Tour Ref :2021/93444

Newlands Hall ,93 High Street ,Heckmondwike WF16 0AL
Erection of 10 Bedrooms and associated works.

*******OBJECTION/PETITION*******

DRAWING TITLE
EXISTING SITE PLAN

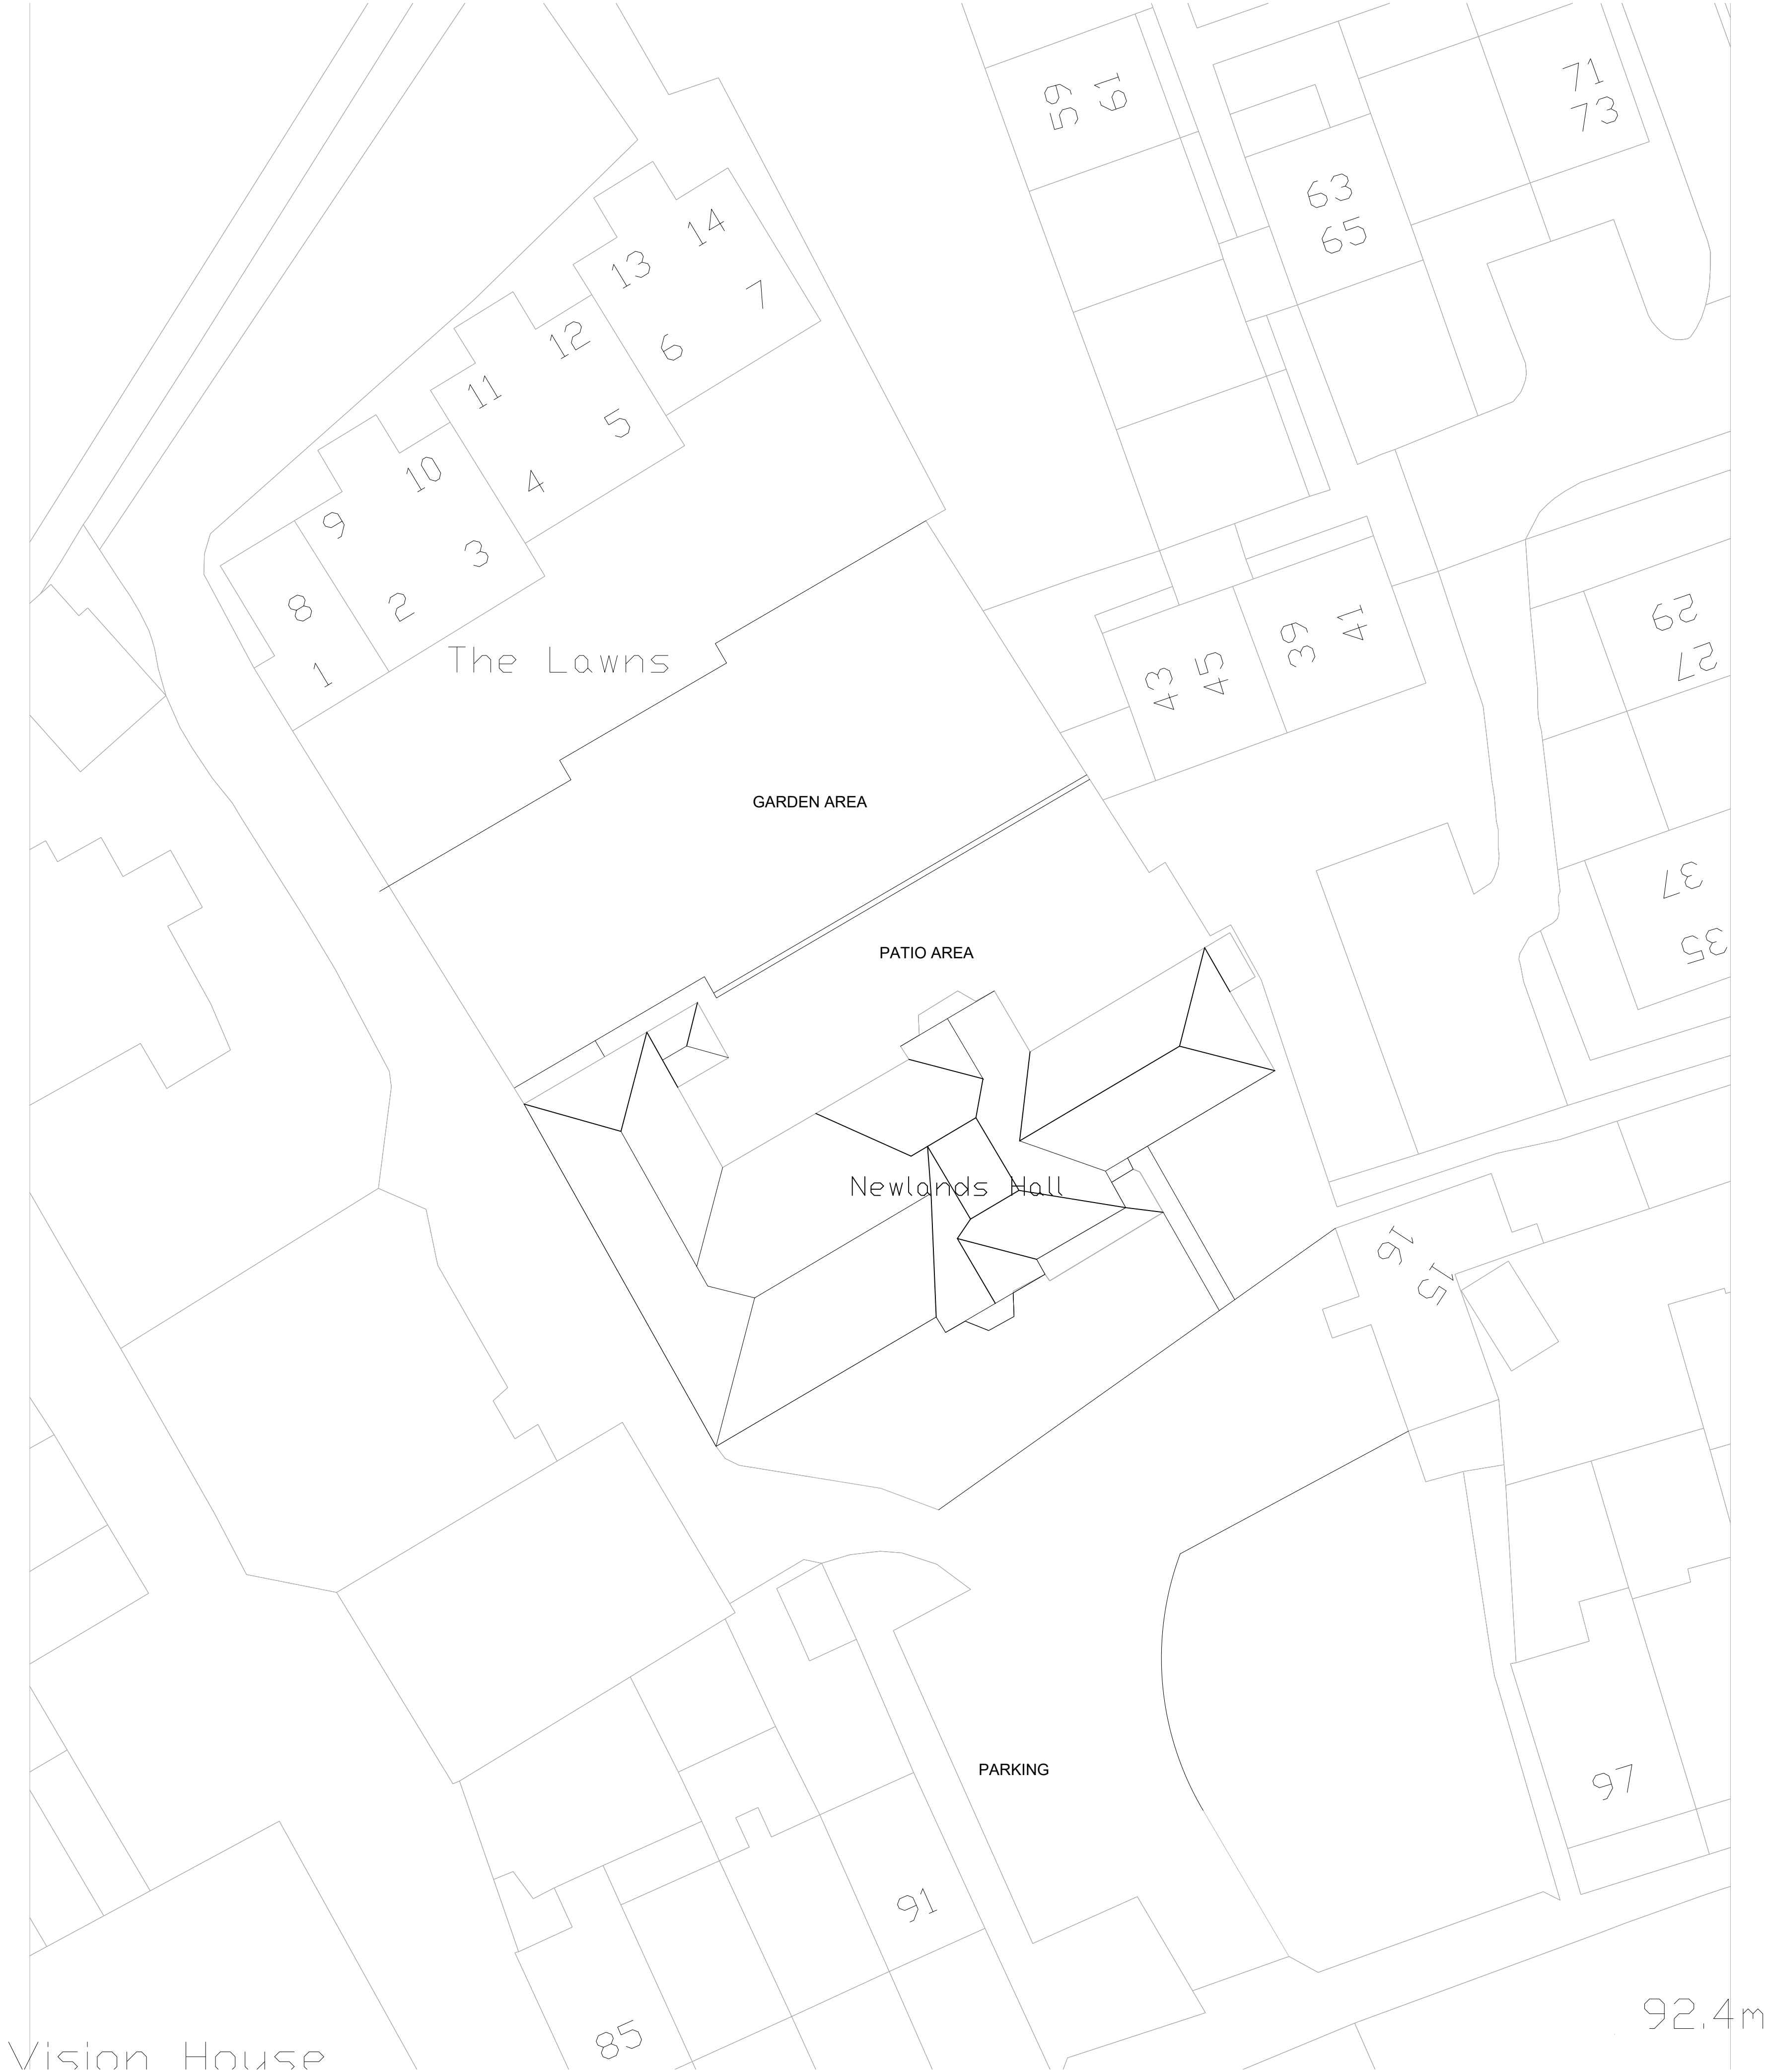
Access

There is only one entrance /exit to Newlands Hall and the flats at The Lawns. This access is off an already very busy high street which has a school almost directly across.

We understand that from the plans there is no application for any changes and or improvements to access. More accommodation will automatically bring more traffic to the site .There is only one access /exit road to the flats which is very narrow and only wide enough for one vehicle at a time and construction traffic and larger vehicles generally struggle.

Emergency service vehicles would struggle to get to the back of the properties whilst these proposed work go ahead.

It is our understanding that all the new build properties are required to have two parking spaces per residence . The application proposes to build 10 new bedrooms thus 20 parking spaces will be required. The plans state only parking for 10 more spaces available.
